Environmental Health Consultation Response	Officer	Alan Taylor
---	----------------	--------------------

Detail: Creation of new artificial grass pitch (AGP) and refurbishment of exis

Address:	Astro Turf Sporting Pitches Edisford Road Clitheroe Lancashire		 <p>Ribble Valley Borough Council www.ribblevalley.gov.uk</p>	
Application Ref:	3/2018/0372	Case Officer:		Mr John Macholc
Response Ref:	3/2018/0372/ENV/01	Issue Date:		21 May 2018

TITLE
 Roefields Sports Fields
 Artificial Turf Pitch
 Elevation

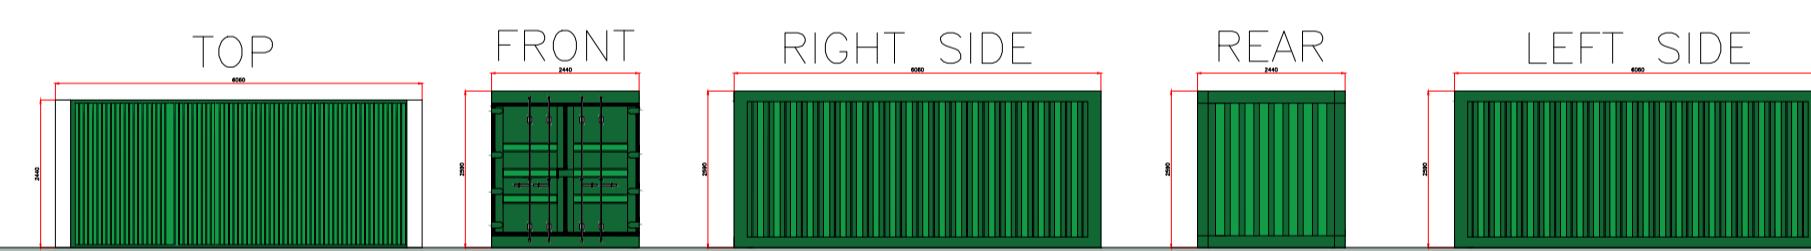
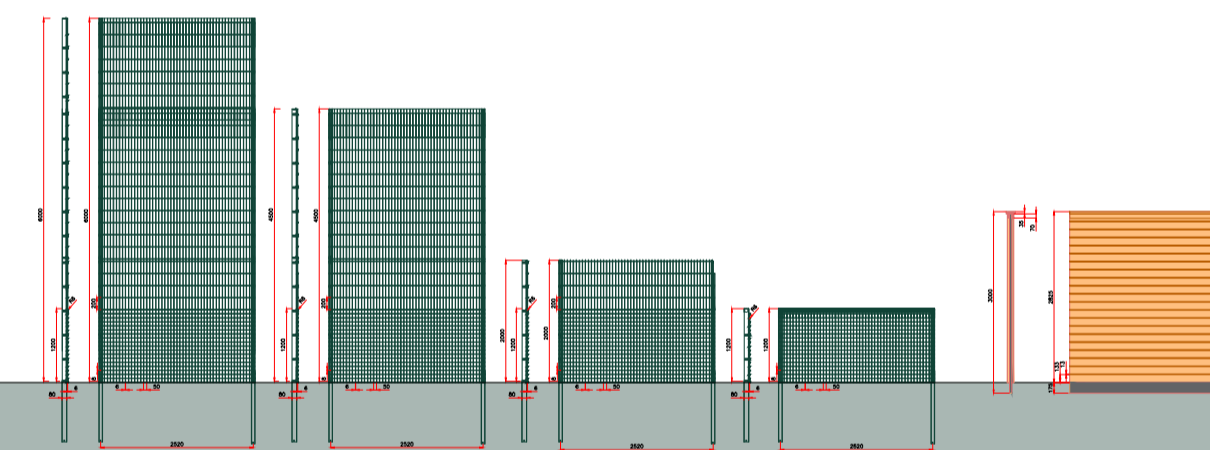
2.1	Noise: The noise assessment has indicated a 3.5 metre acoustic fence is to be erected on the south elevation of the newly developed artificial grass pitch. Whilst this offers reduced noise levels to the nearest residential property (Roefield House) across Edisford road, there is concern of the predicted noise levels which will have an impact upon the North & East residential properties of St Annes Square and the new properties located on Vicarage Close. Further acoustic fencing would help to reduce the incidence of noise from the developed site having an impact on these properties.

2.5	Should you be minded to approve the application, notwithstanding other considerations, I would suggest that the following conditions be attached should you feel they are relevant and justified: <ul style="list-style-type: none"> Noise conditions should not exceed the lowest observed effect level of 35 LA_{eq} in the nearest residential property. The hours of use to be conditioned Monday – Friday from 09.00hrs to 21.00hrs.

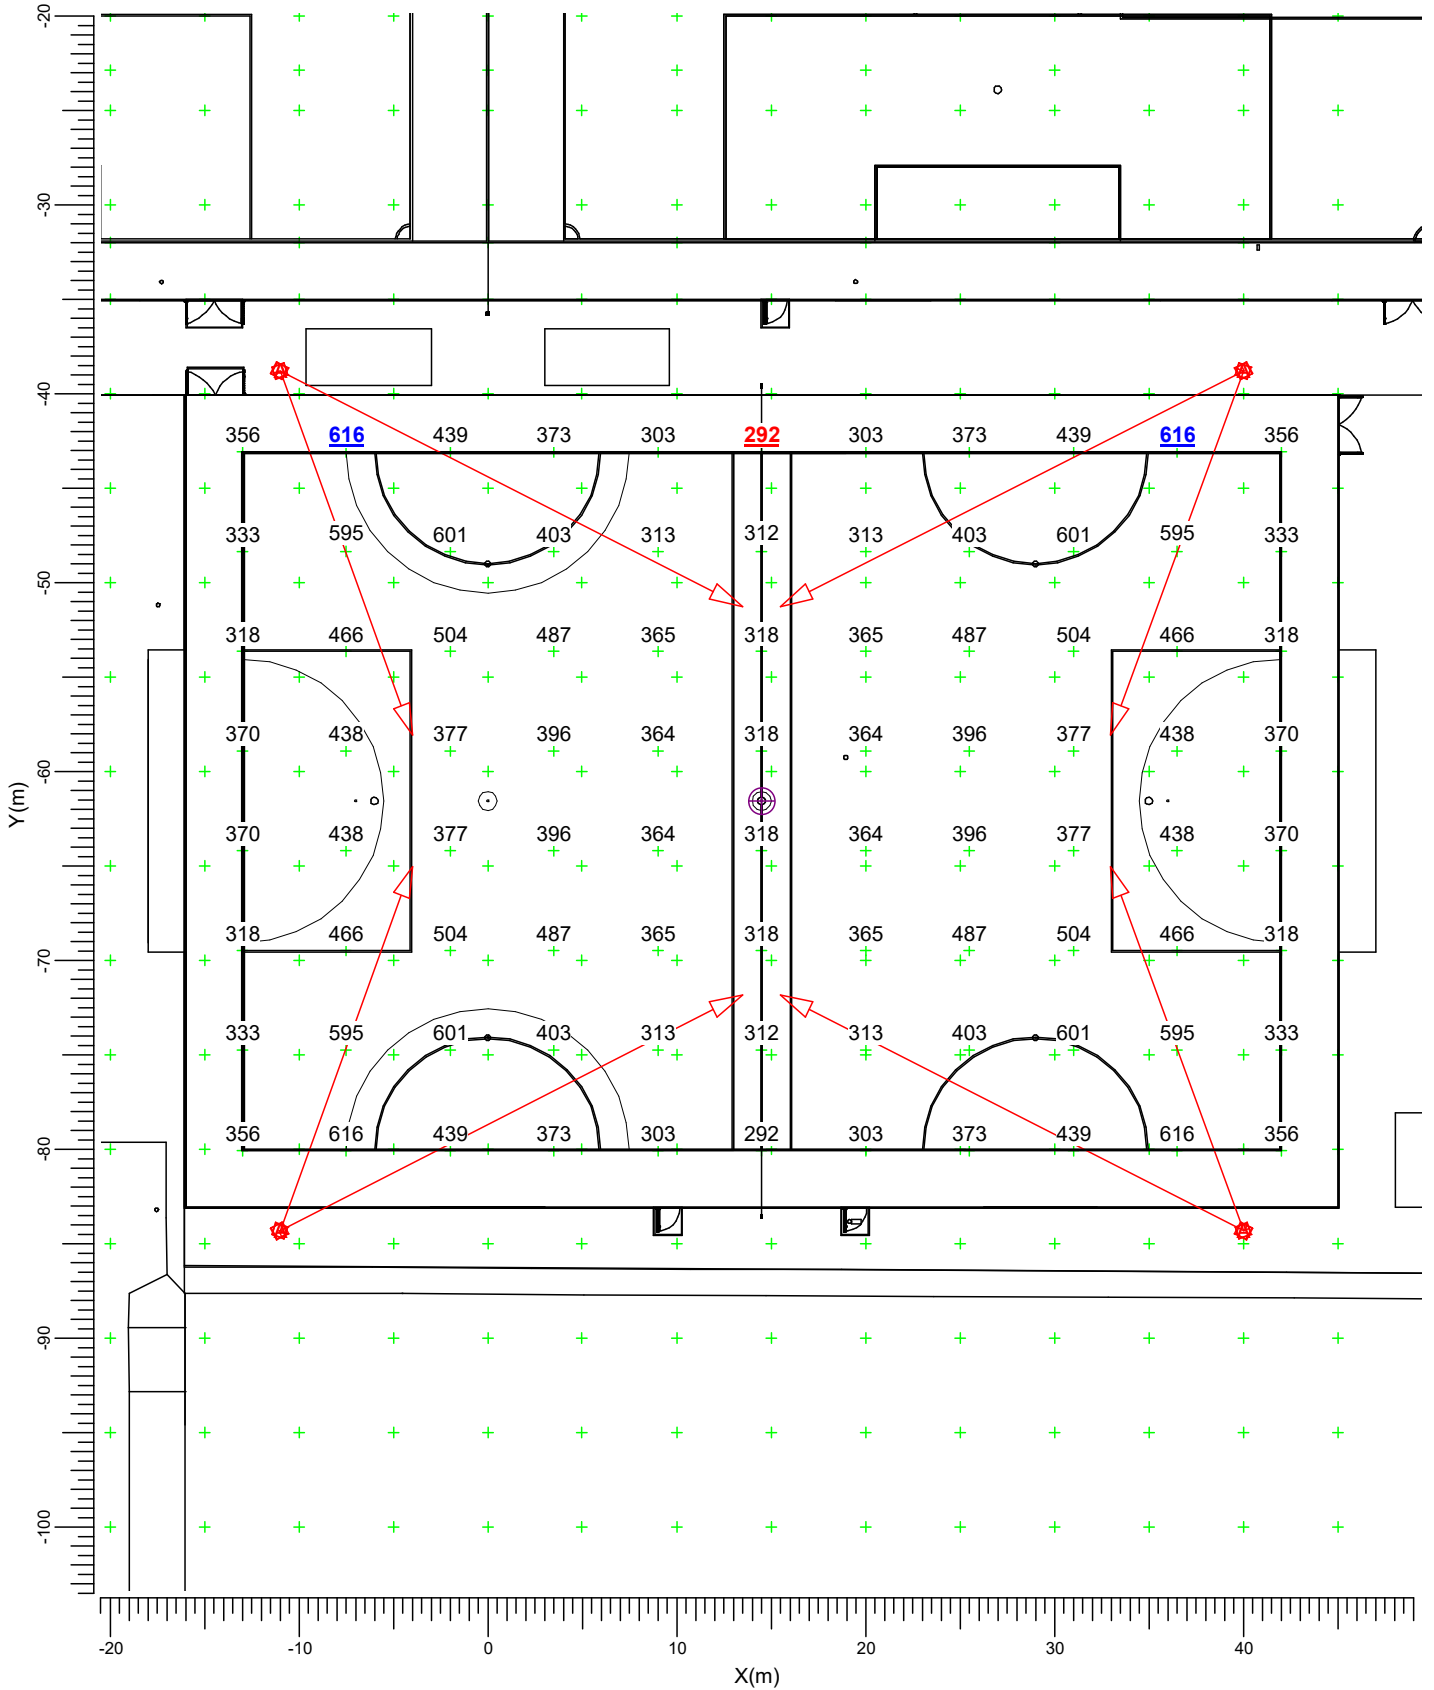
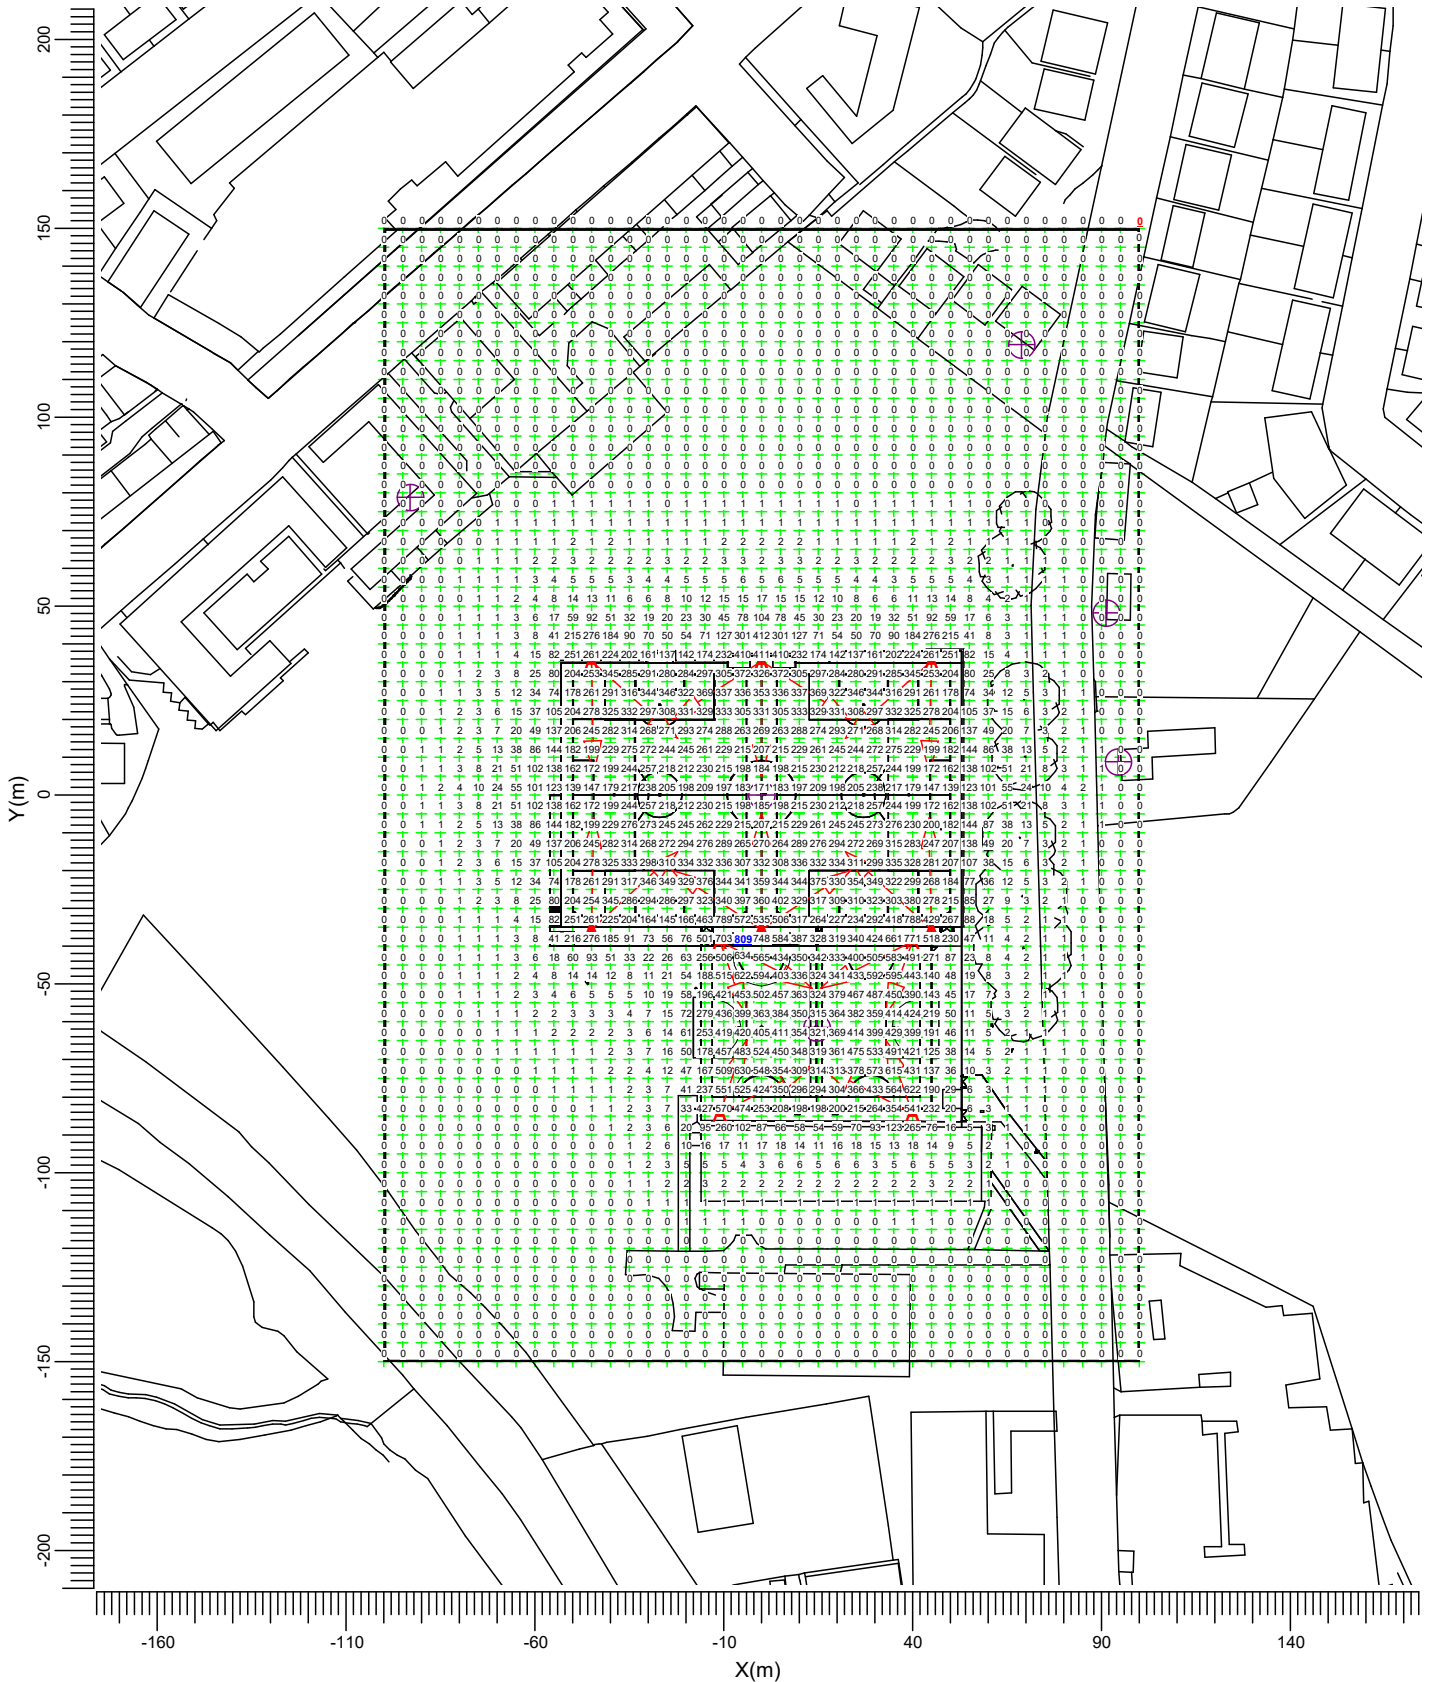
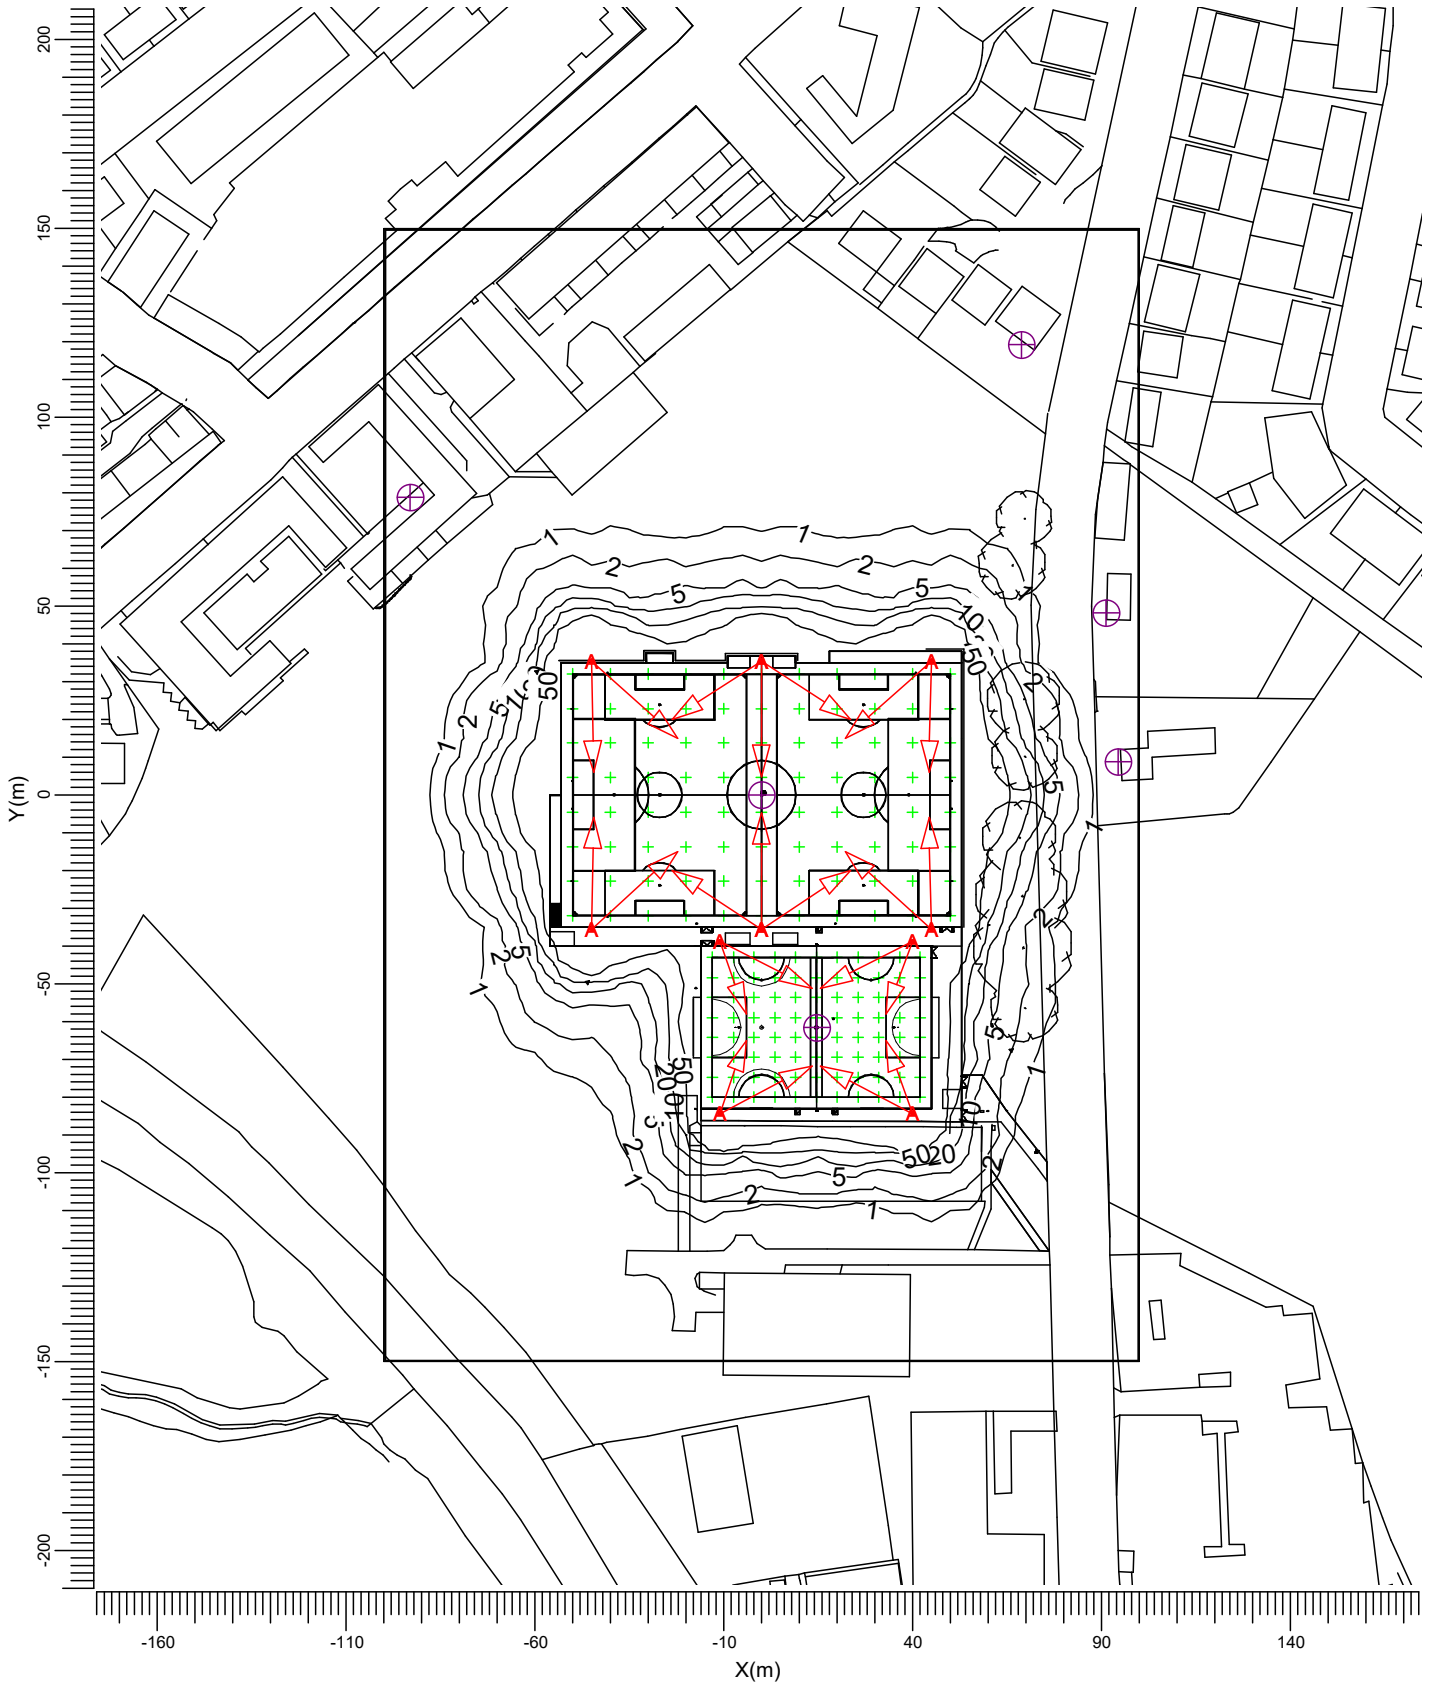
2.2	Lighting: The lighting to be installed to illuminate the proposed area must not allow spill light to extend beyond the boundary of the grassed field perimeter. This will remove the possibility of stray light causing nuisance to residential premises around the sports area. This may also be controlled by correct positioning and final adjustments being completed using light deflectors if required.

- Condition the proposed lighting of the sports area to prevent any stray light extending beyond the site boundary.
